# Issue and Revision Record

**Document reference:** 100414124 | TPN | ITD | 044 | 002 | A

# 1 Introduction

This report describes a Stage 1 Road Safety Audit carried out on the proposed access arrangements for a new 280,000m<sup>2</sup> employment development on land adjacent to the M40 J10. Two access points (eastern and western) will be provided either side of the A43 / B4100 Baynards Green roundabout junction. This audit report considers the eastern access.

JOB TITLE		M40 JUNCTION 10		CLIENT		ALBION LAND	
DRAWING TITLE							
EASTERN ACCESS PRE-GROWTH FUND							
SCALE	DRAWN BY	DATE	DRAWING No	REVISION			
1: 250@A1		03/08/21	17213-16

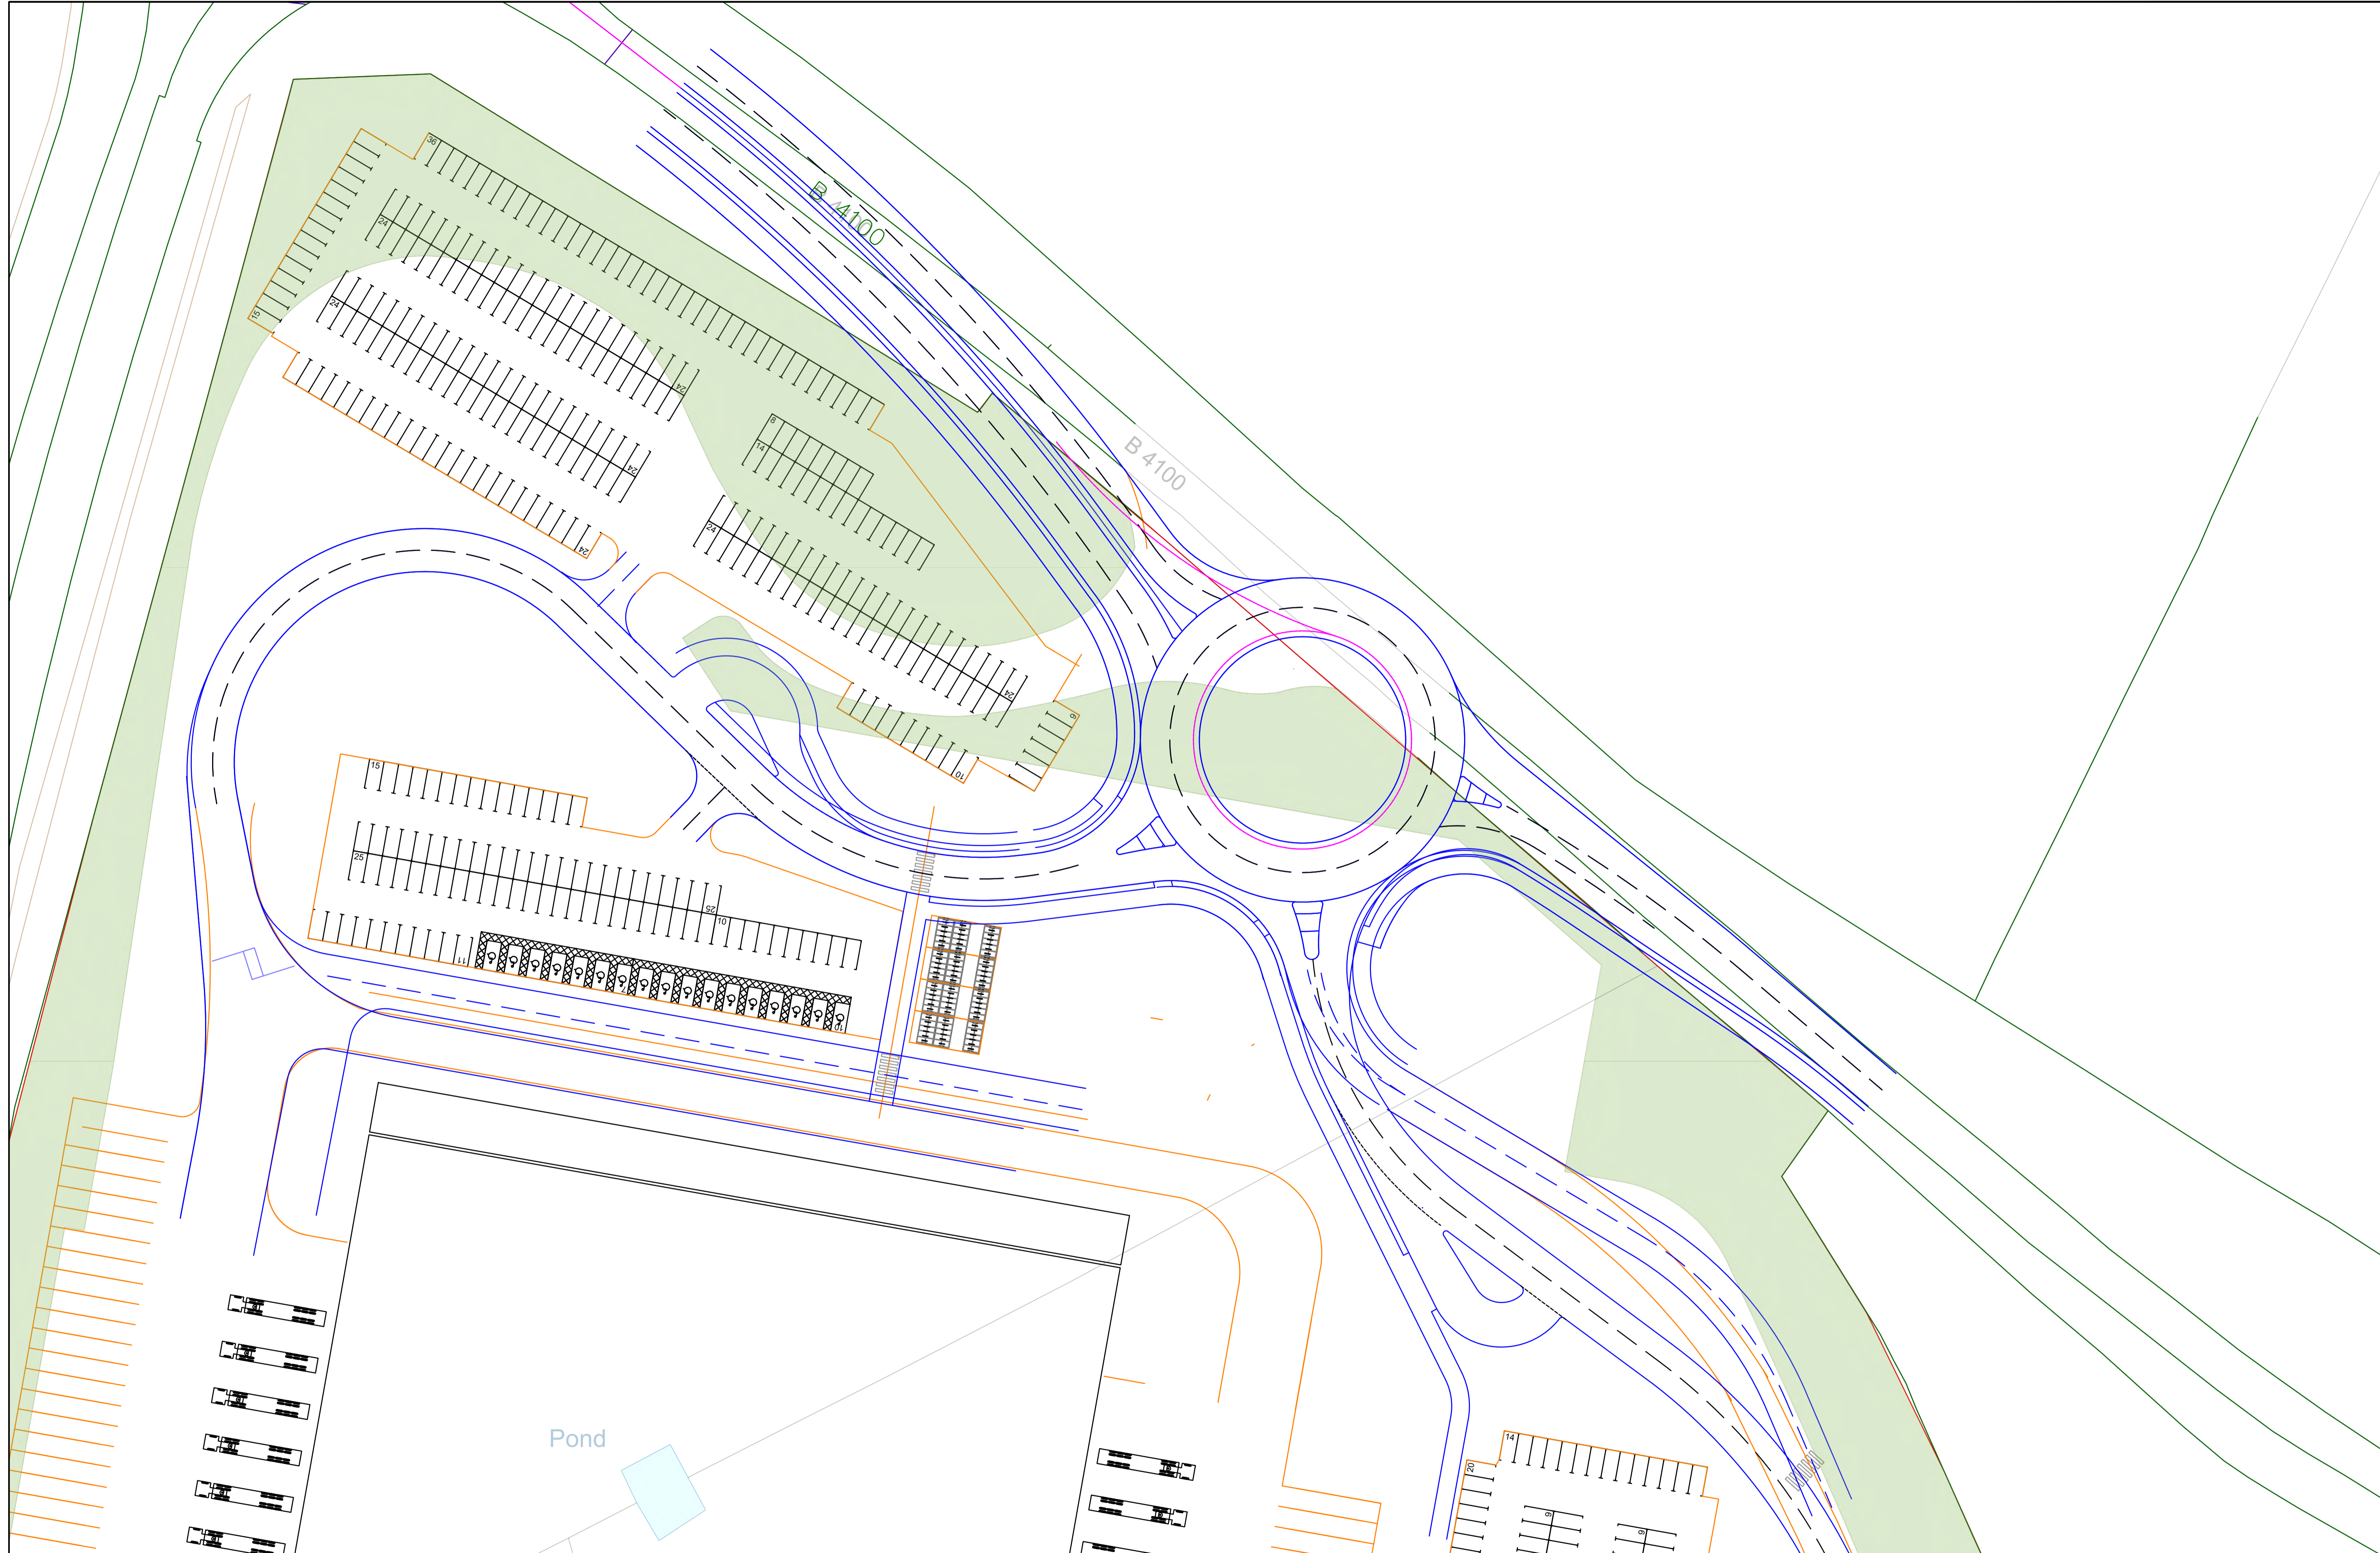
*Location:* B4100 Roundabout junction.

*Summary:* Unclear lighting provision may lead to loss of control collisions.

The proposed roundabout junction is in close proximity to the existing A43 Baynards Green junction where street lighting is present. It is not clear from the information submitted if it is intended to light the proposed roundabout. The existing street lighting extends to the tie-in between the new and existing highway. Failure to light the new roundabout will result in south-eastbound motorists transitioning from lit to unlit on the immediate approach to the junction. This may result in motorists misjudging the position or geometry of the roundabout during the hours of darkness, increasing the risk of loss of control type collisions.

It is recommended that the proposed roundabout is lit and that the lighting appropriately ties-in with the existing street lighting.
